From: rogersbigtone [REDACTED]
Sent: 12 May 2021 08:49
To: Kathryn Welch <Kathryn.Welch@arun.gov.uk>
Subject: RE: K/18/21/CLP 32 Golden Avenue

From: Kathryn Welch <Kathryn.Welch@arun.gov.uk>
Date: 11/05/2021 14:12 (GMT+00:00)
To: [REDACTED]
Subject: K/18/21/CLP 32 Golden Avenue

Note: All materials to match existing

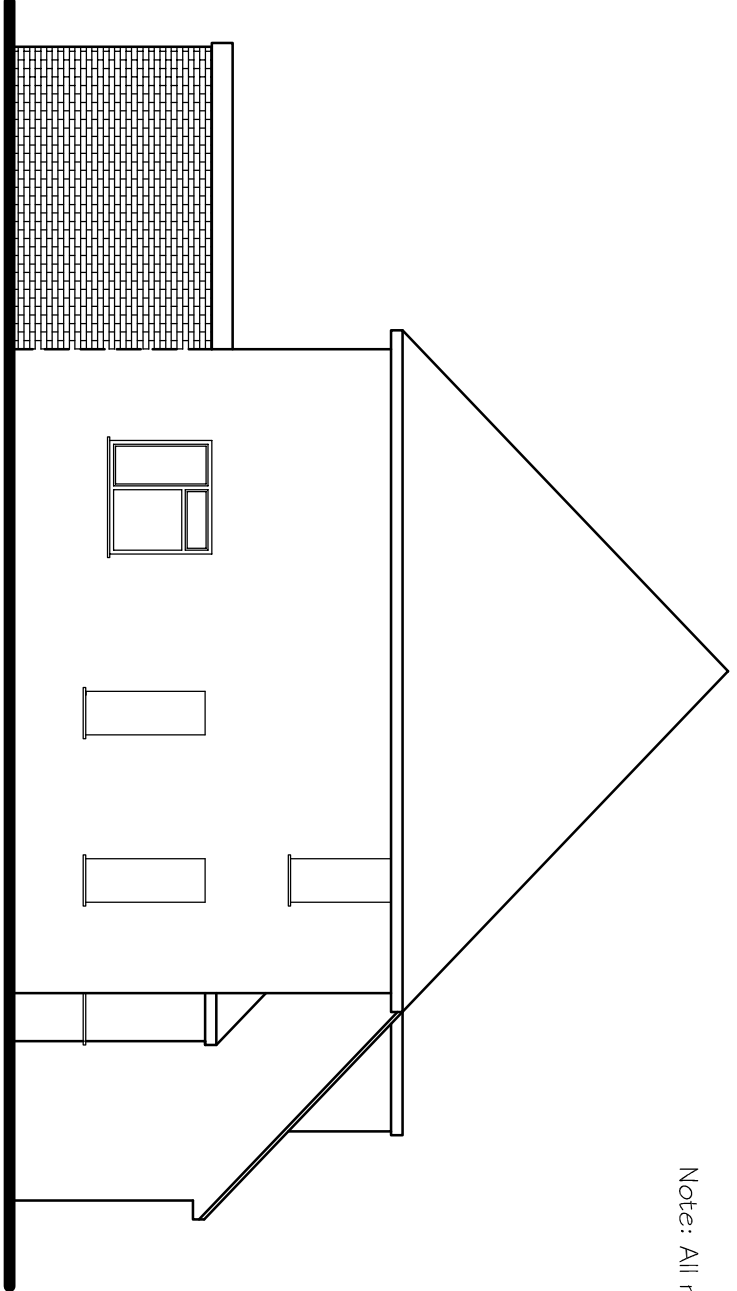
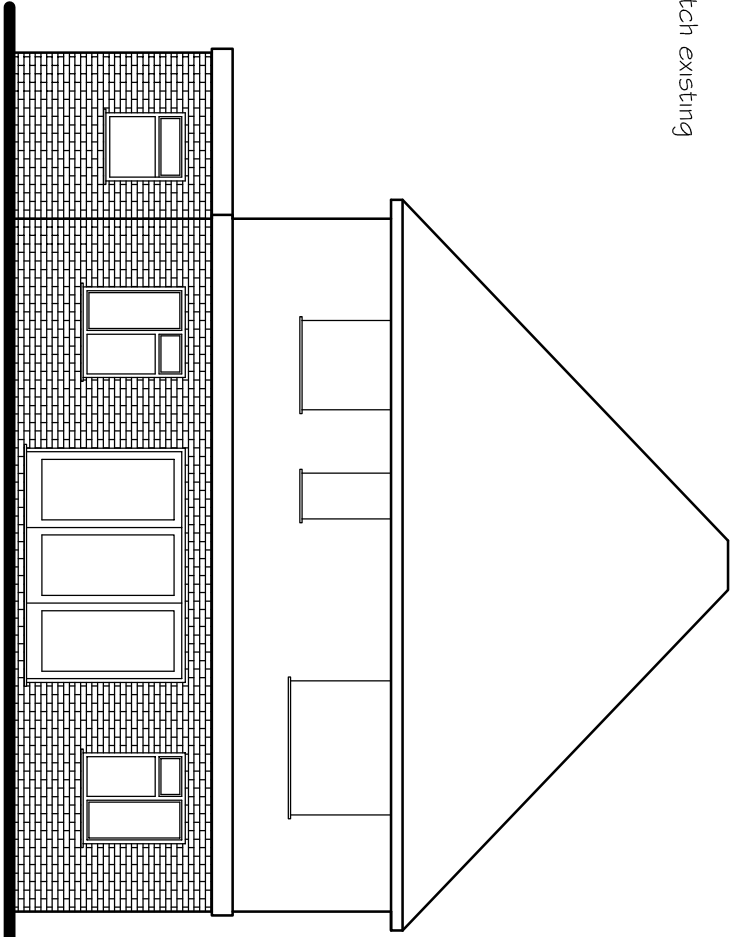
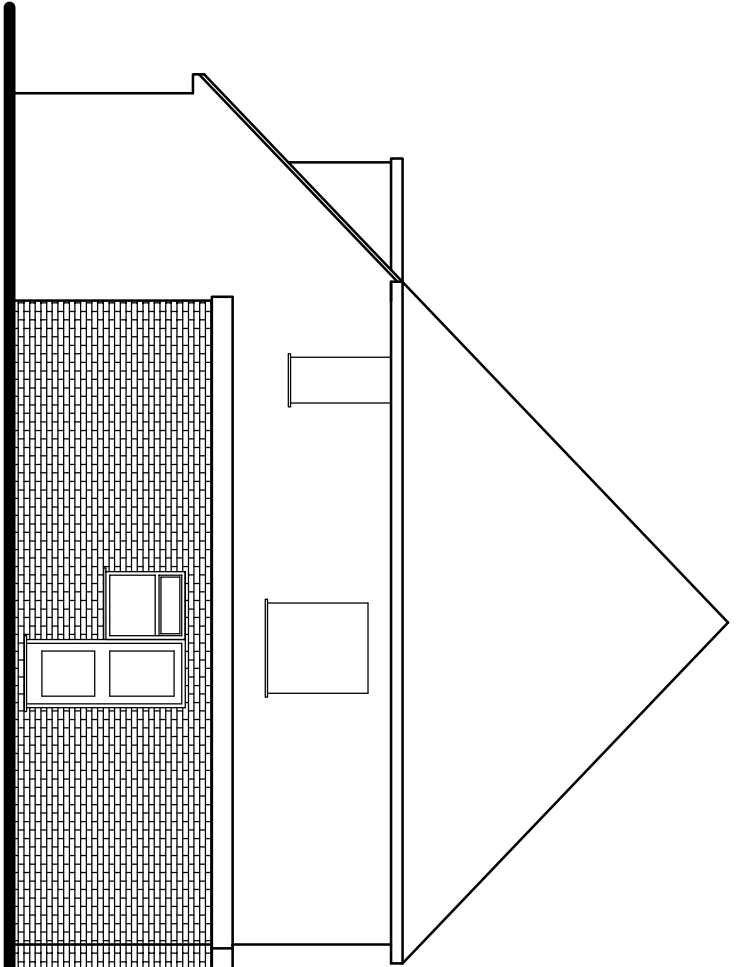
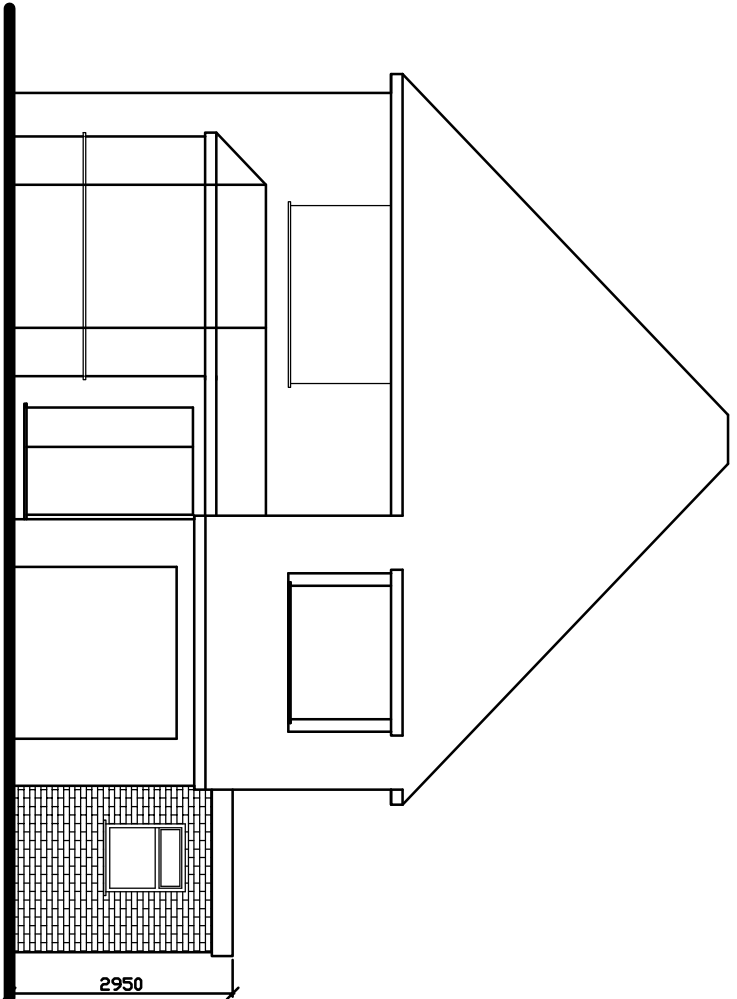
I'm currently looking at writing up the report for the above mentioned application. Could you confirm for me that it will be built of materials similar to those found on the existing building?

I can confirm it will be constructed in materials to match the existing.
